Gatwick Airport Northern Runway Project

Environmental Statement

Appendix 9.3.3: Summary of Stakeholder PEIR – Ecology

Application Document Ref: 5.3

Title
Surface Access Highways Plans
Structure Section Drawings
APFP Regulation 5(2)(o)
Sheet 2
A23 London Road Bridge over River Mole

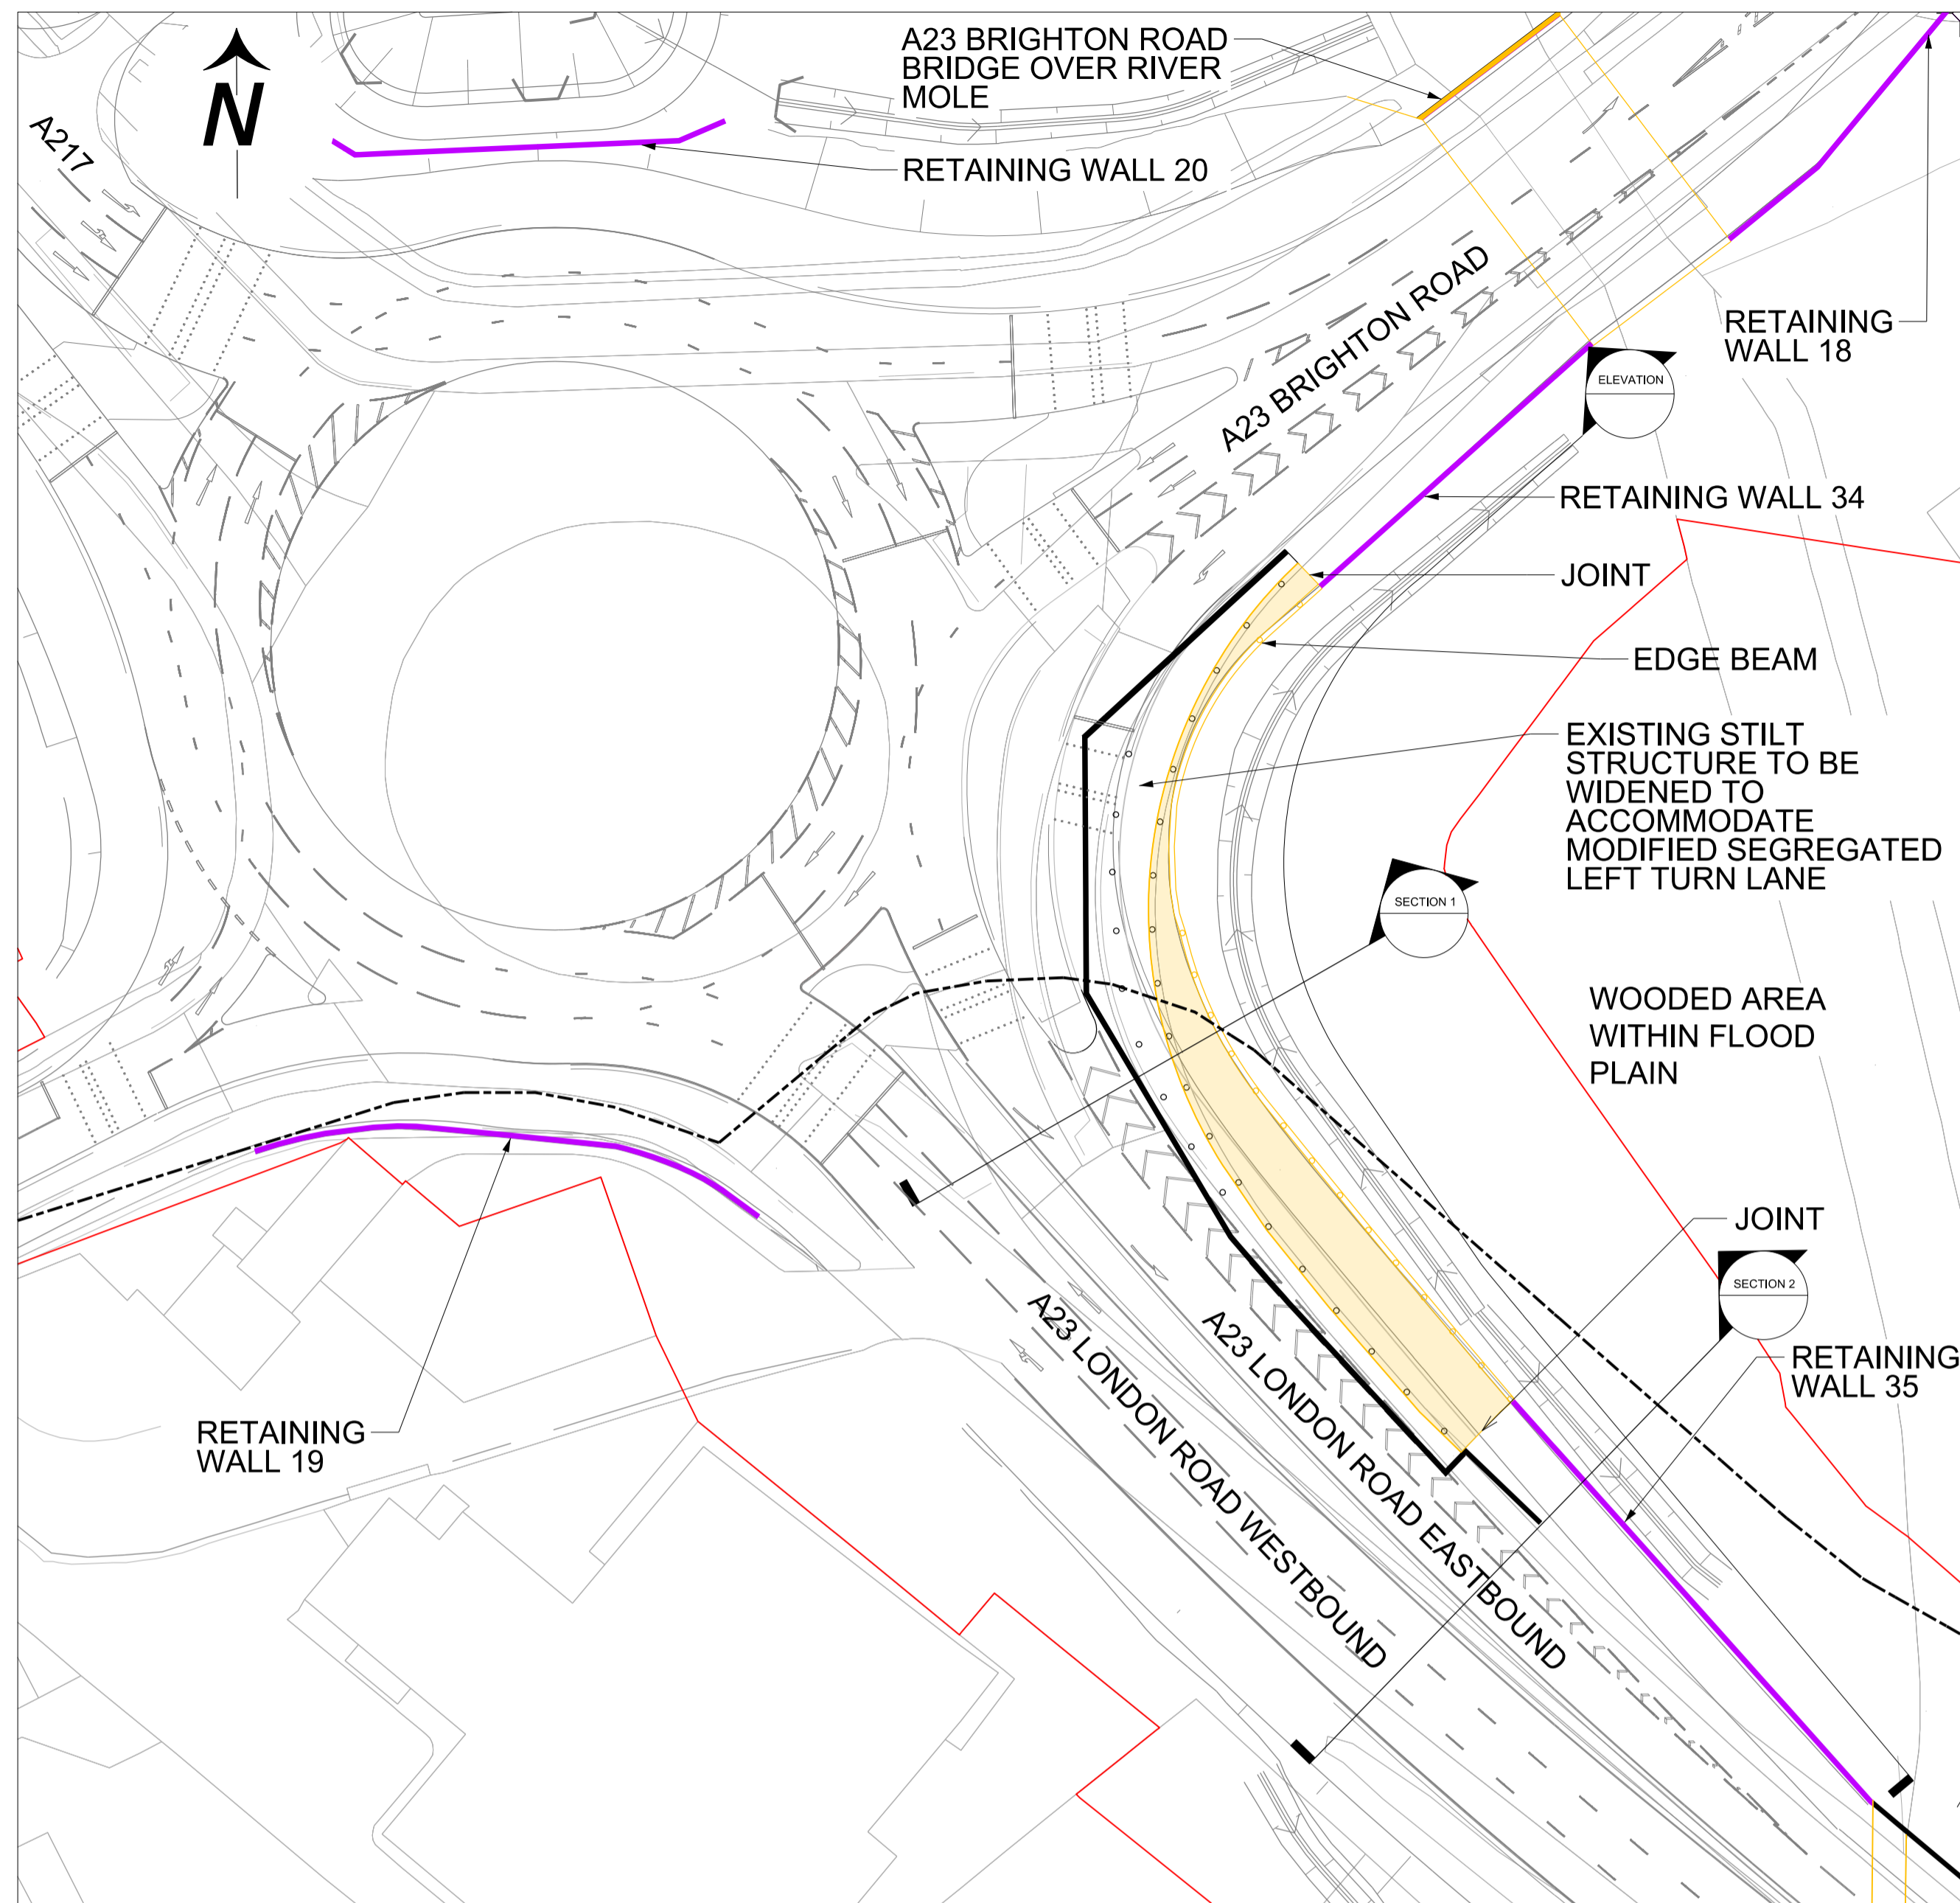
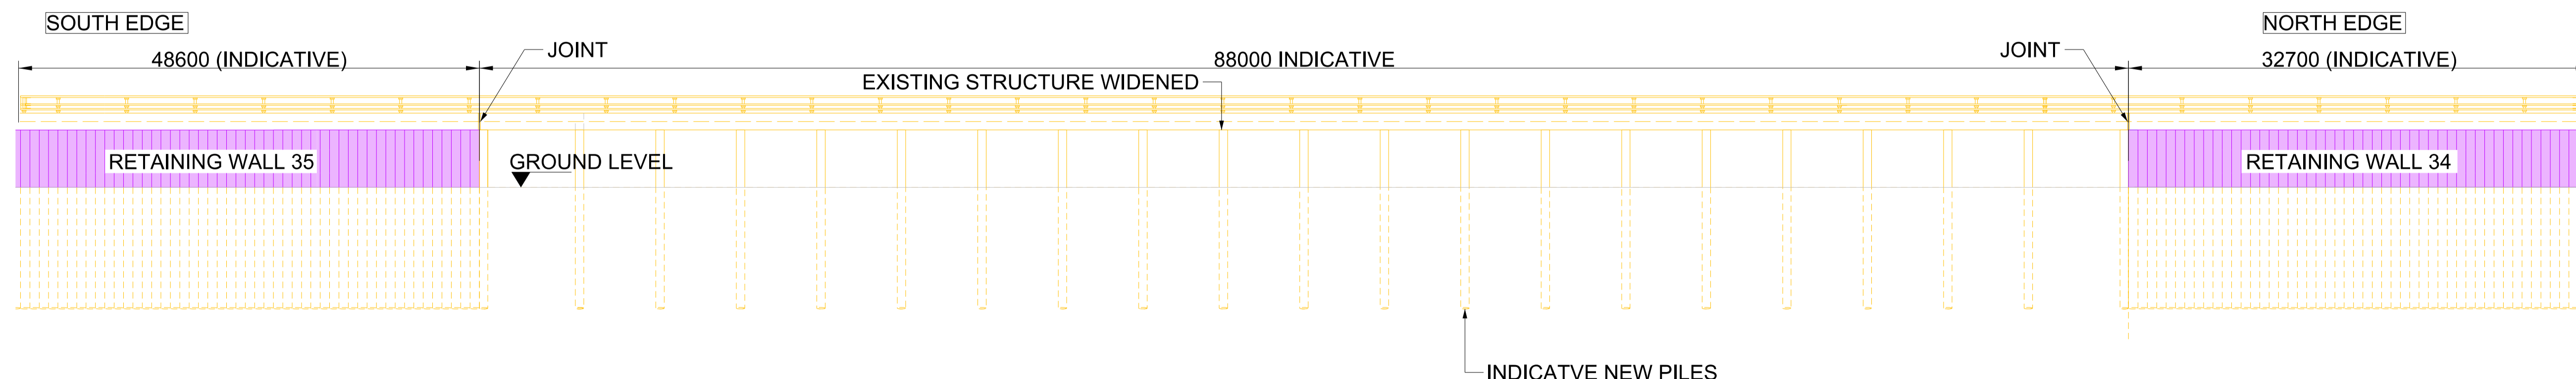
West Sussex County Council	27 July 2022	A23 London Road (5): There is no mention of potential ecological impacts resulting from the proposed widening of the highway bridge over the River Mole, other than those during construction. There could be impacts due to increased shading of the watercourse and marginal vegetation, and a greater barrier to the movement of wildlife, including bats, under a wider bridge. Reference is made to a rights of way strategy, which would include a new pedestrian and cycle link between North Terminal and Longbridge Roundabout. No further details are given so it is not possible to assess any potential ecological impacts upon habitats and species.	Noted. These potential impacts relating to biodiversity are addressed in Section 9.9 (chapter 9 of the ES).
West Sussex County Council	27 July 2022	Longbridge Roundabout (6): The crossing of the River Mole would result in some loss of vegetation. This is likely to be ecologically sensitive and will require very careful consideration and design.	Noted. The assessment of the effects of vegetation loss resulting from the surface access improvements is included in Section 9.9 (Chapter 9 of the ES).
